Submission to SSD-61000021 at 146 Arthur Street, North Sydney

Stockland Corporation Limited (**Stockland**) submits this response to the State Significant Development Application (**SSDA**) for build-to-rent housing that is currently on Public Exhibition at 146 Arthur Street, North Sydney (SSD-61000021). Whilst Stockland supports the transformation of North Sydney with new commercial and residential developments to create a vibrant place, we object to this proposal and urge the Department of Planning, Housing and Infrastructure (**DPHI**) not to support the scheme in its current form. Our objections, as outlined throughout this letter, relate to the following matters:

1 Section East/West
SCALE 1 : 500

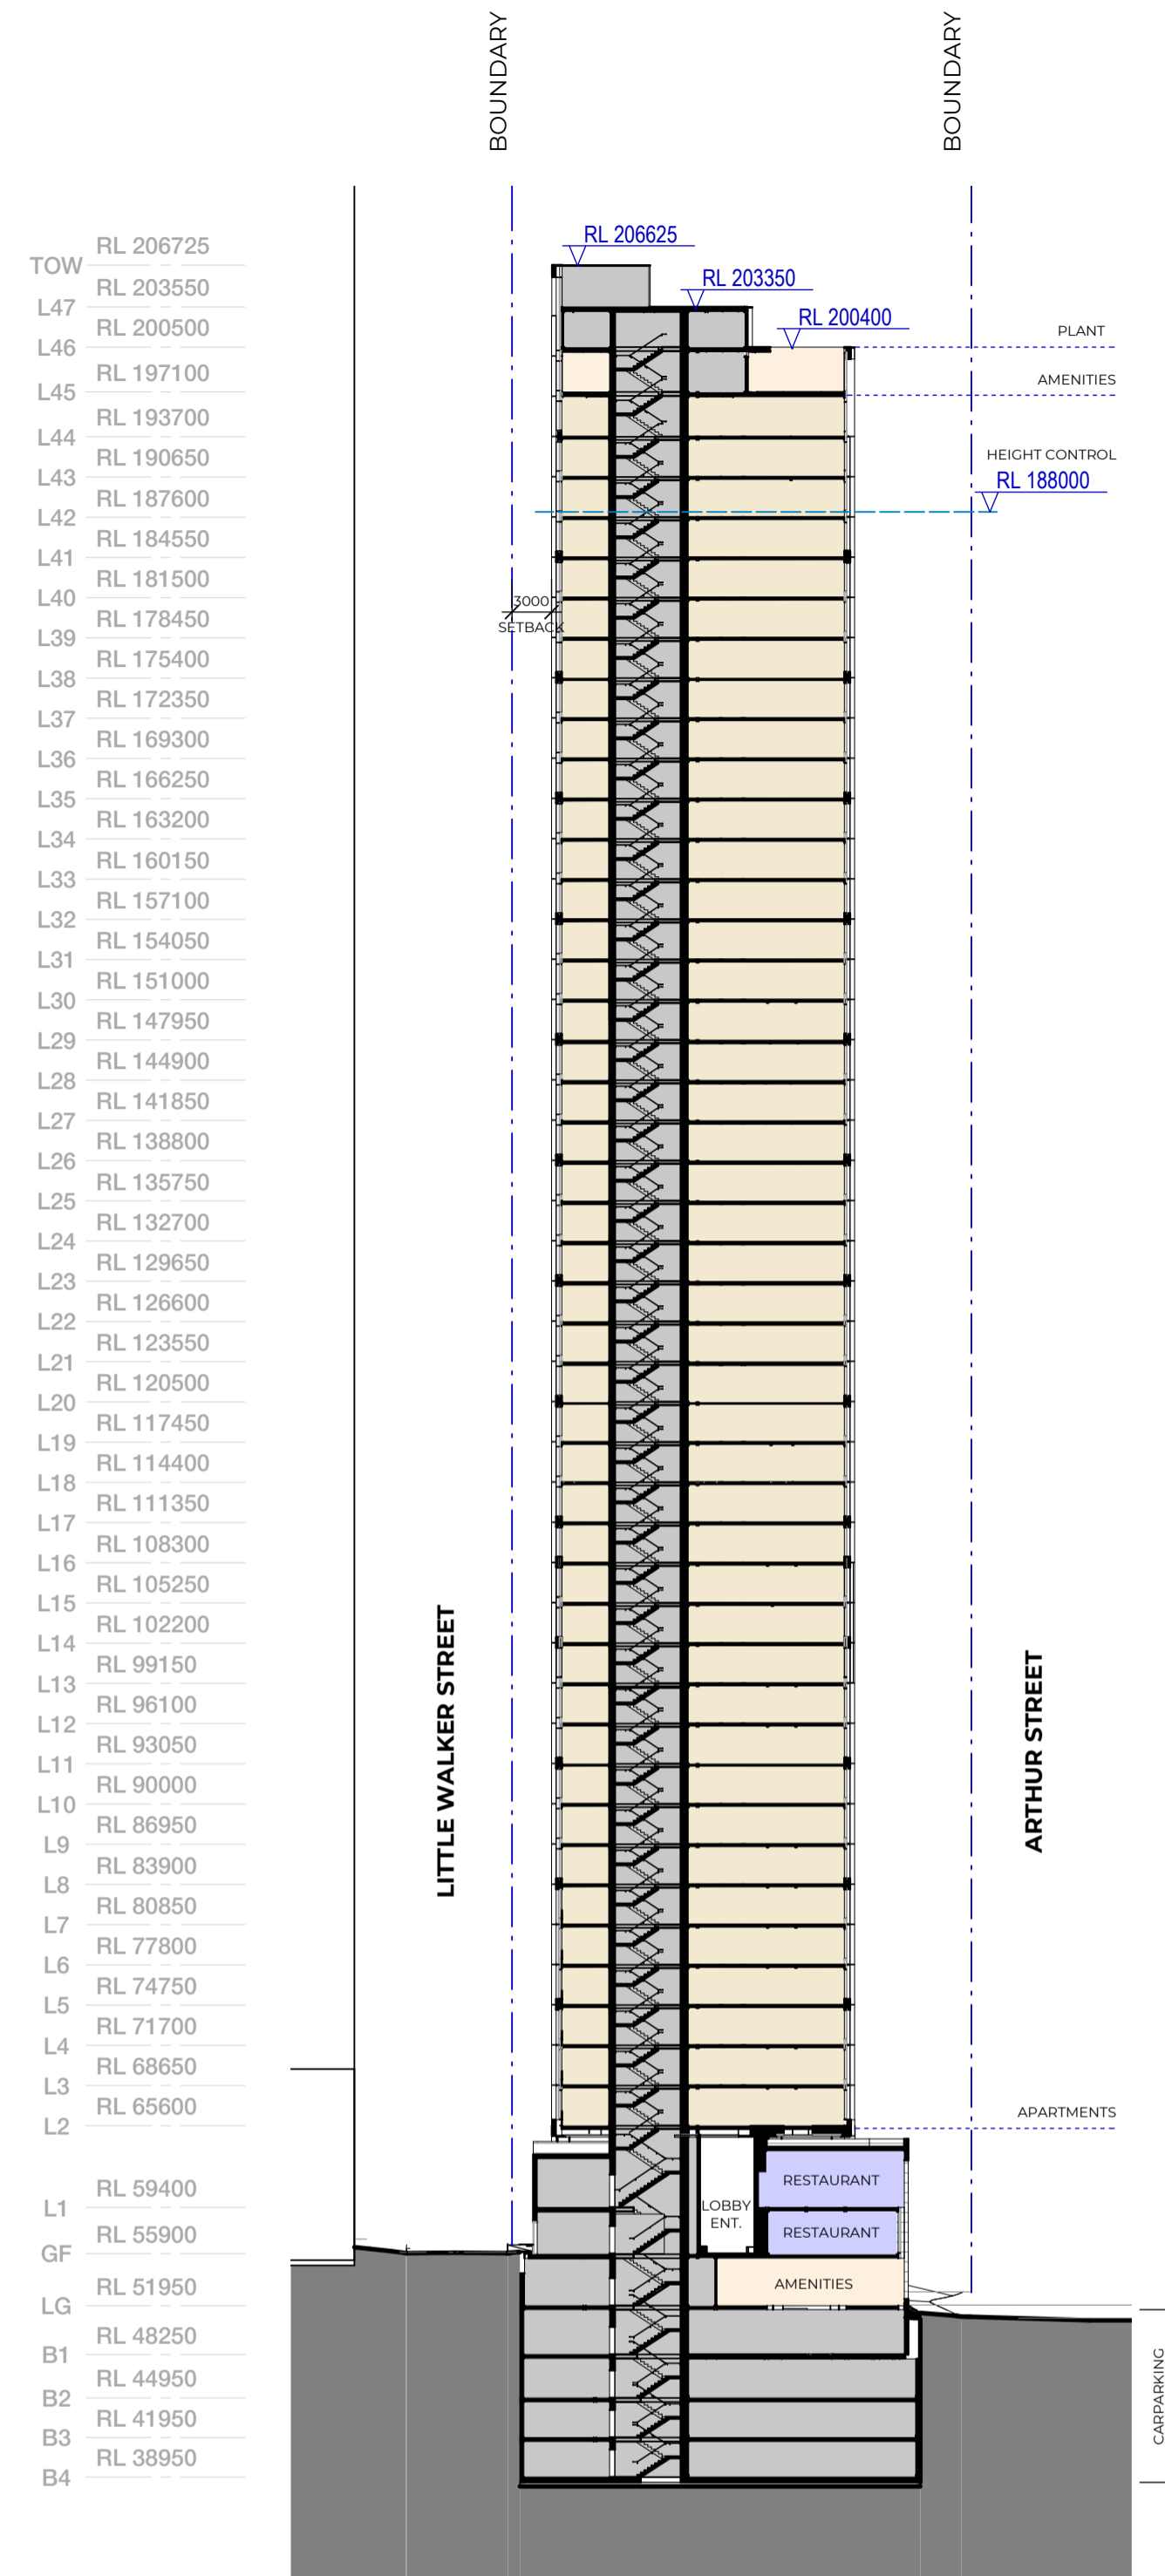
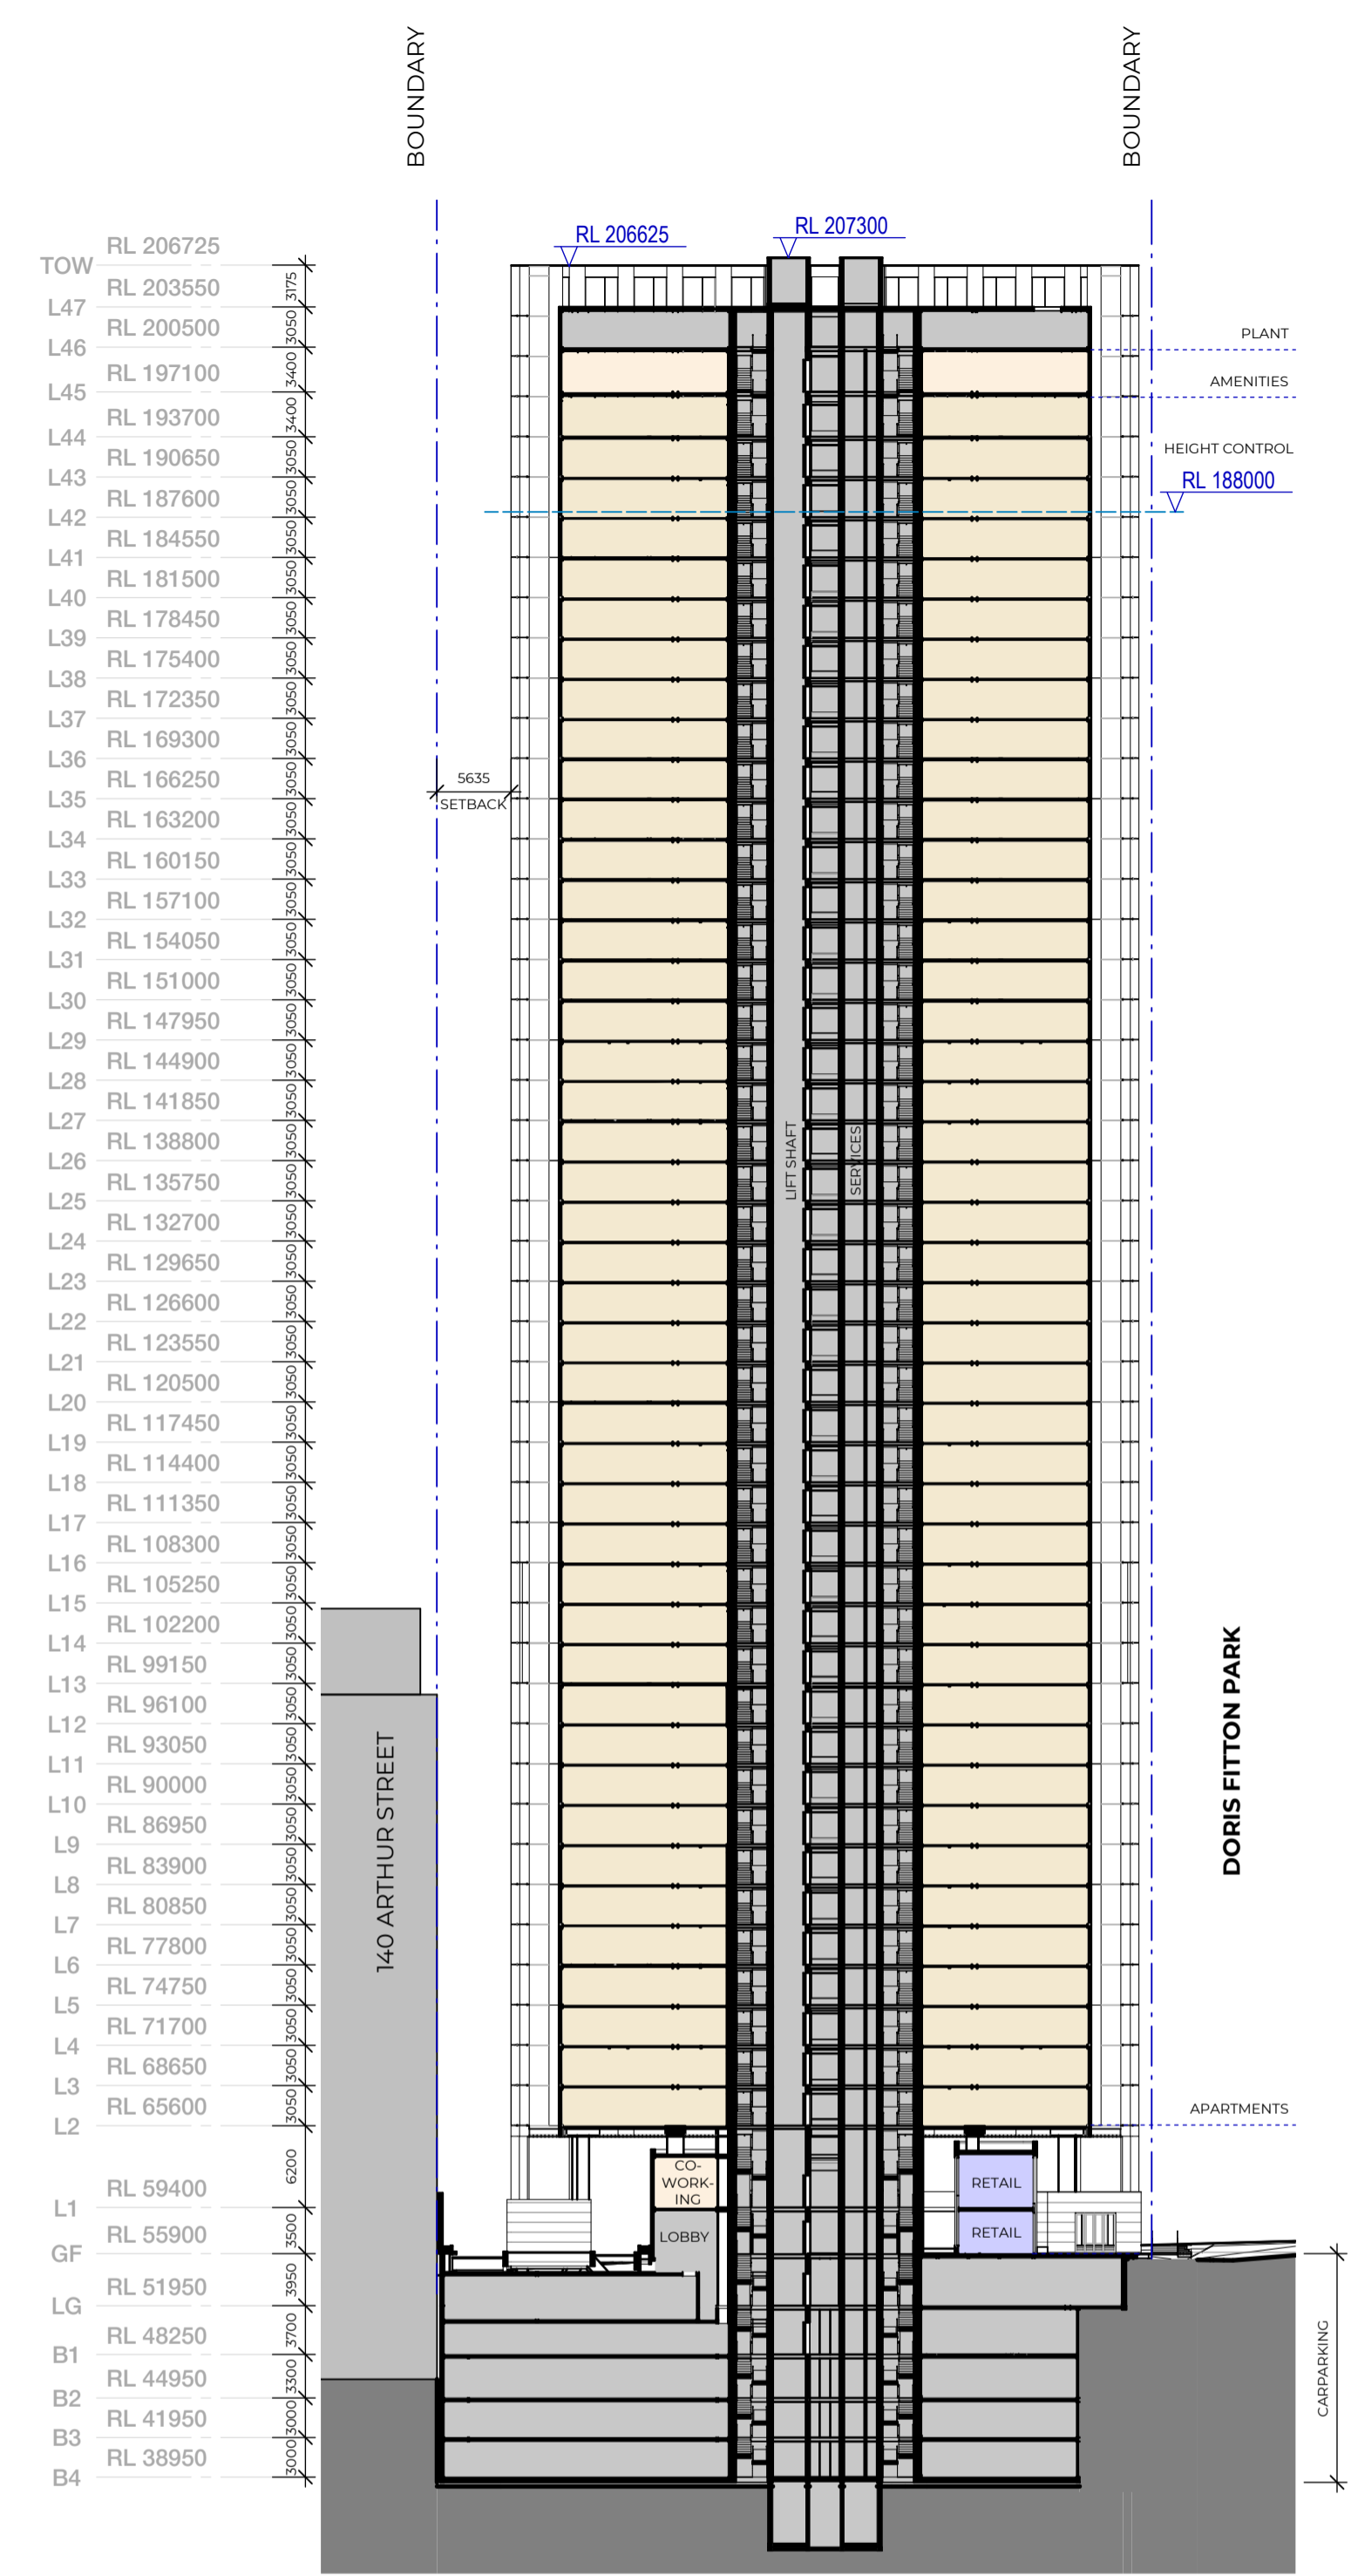
The proposed height variation for 146 Arthur Street (10.23% of the permitted building height) will result in substantial view loss that is not reasonable to anticipate under Clause 4.3 of the NSLEP 2013. 146 Arthur Street is located at the edge of the CBD, which is bound by the Warringah Freeway. Due to the location of 146 Arthur Street and the substantial height variation, the extent of view loss imposed on surrounding development, including the approved commercial tower at 153-157 Walker Street and Affinity Place, will not be acceptable.

The proposed extent of view loss is considered to be unacceptable in the context of the view loss principles set out in *Tenacity Consulting v Warringah Council*, given a substantial amount of this view loss would be attributed to building mass that is located above the maximum permitted building height. When considering the reasonableness of a proposal that causes a view impact, the principle sets out that 'where an impact on views arises as a result of non-compliance with one or more planning controls, even a moderate impact may be considered unreasonable'. Noting that the proposal does not comply with the maximum height control, provides a reduced side setback control and does not provide any public benefit relative to these proposed variations we submit that the view impacts are unreasonable and the applicant should be requested to amend the proposal such that it complies with the relevant building envelope controls.
